From: Amanda Scholes
Sent: 21 May 2019 09:27
To: Planning Scanning
Subject: FW: FP/103/19 - Green Space off Stanhorn Grove, Felpham

FP/103/19/PL

From: Richard Wickens [REDACTED]
Sent: 13 May 2019 11:00
To: Joe Russell-Wells <[REDACTED]>; Anthony Baker [REDACTED]
Cc: David Smart <[REDACTED]>
Subject: FP/103/19 - Green Space off Stanhorn Grove, Felpham

Drawing Title:
CHANGING FACILITIES BUILDING
SITE LAYOUT

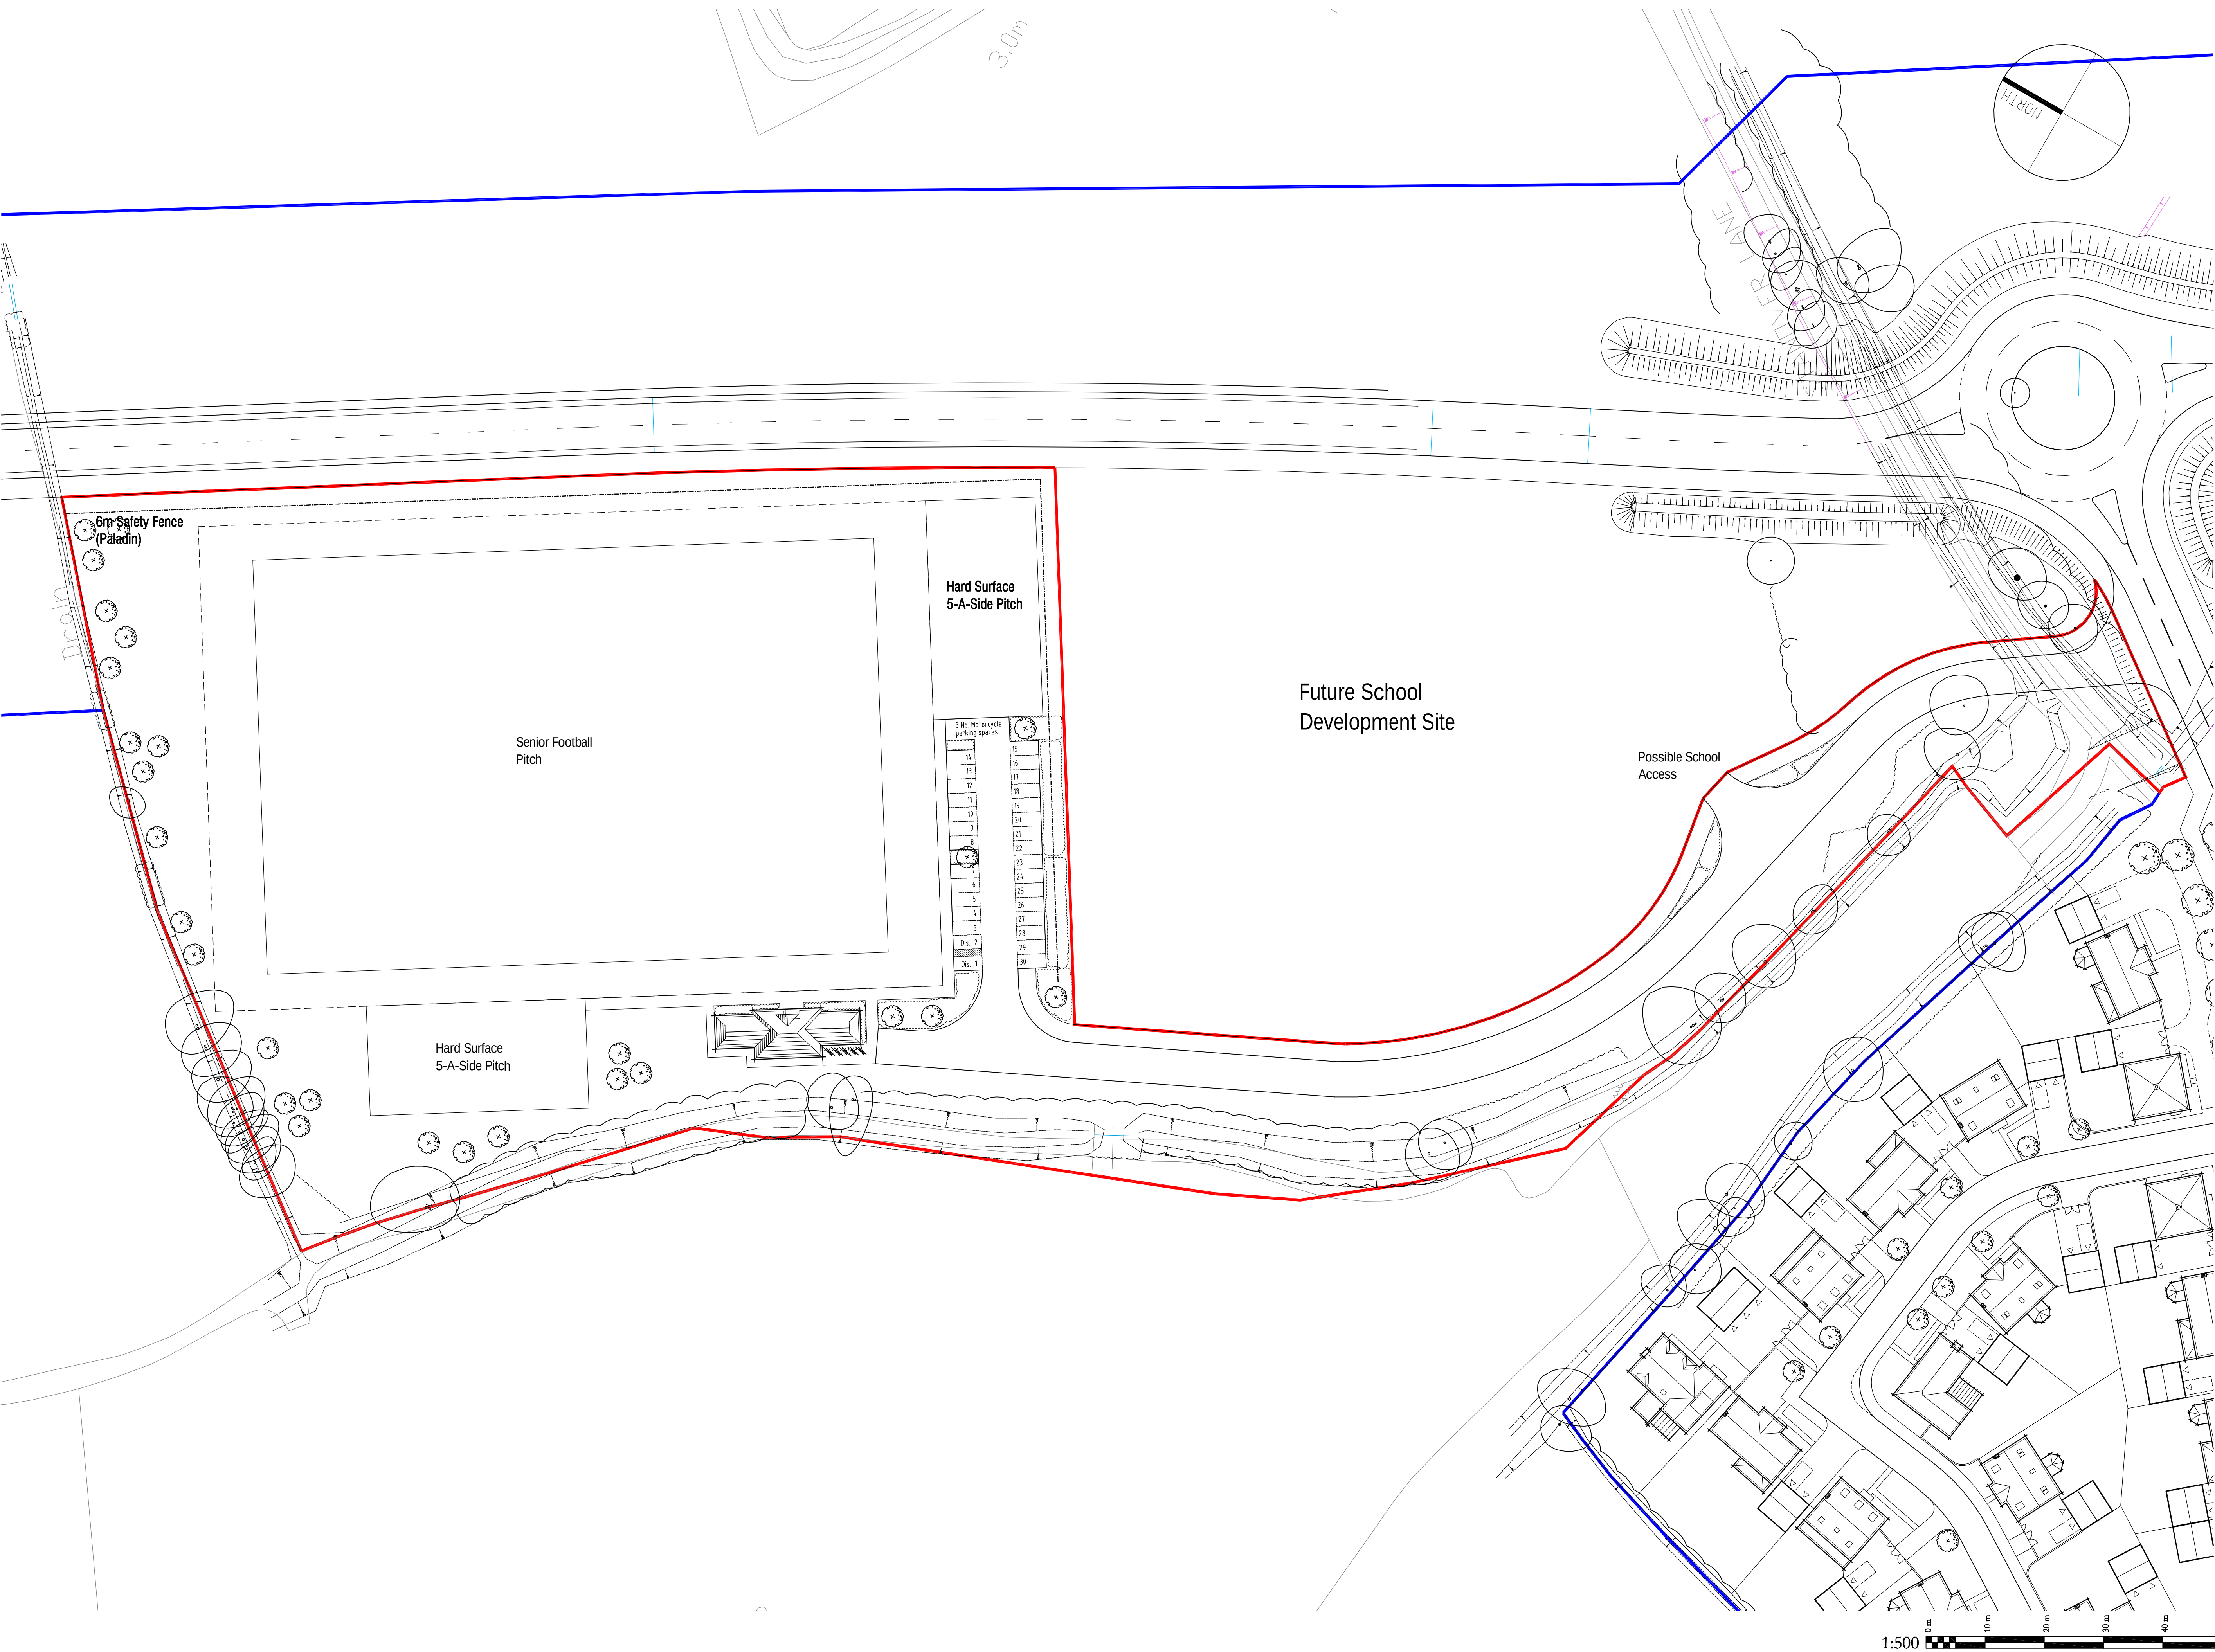
Site Safety:

- Insufficient detail about fencing.
- Insufficient detail about prevention of vehicles accessing the green space and using it as a vehicle playground at risk to pedestrian users/dog walkers etc.
- The need for significant and effective speed bumps/control measures to be introduced on the road in to the area to control speed.
- Lighting should be provided on the road to the car park and the car park itself.

Site security:

- There is insufficient detail about how to preventing access to larger vehicles, caravans, motorhomes.
- This location will be a prime site for travellers so robust height limiting bars must form part of the initial access
- The site could also be attractive to so called “boy racers” or people using as a location to show off their vehicles so prevention measures must be in place.
- Any access point to the greenspace area must be protected by robust gating which prevents unauthorised access.
- Will the site have road access fenced off and closed during the night in keeping with some other areas in Felpham. Footpaths, cycle access to remain open.
- A bye law is needed making it illegal for overnight stays, including camping, caravans, motor/mobile homes, dumping of rubbish etc.
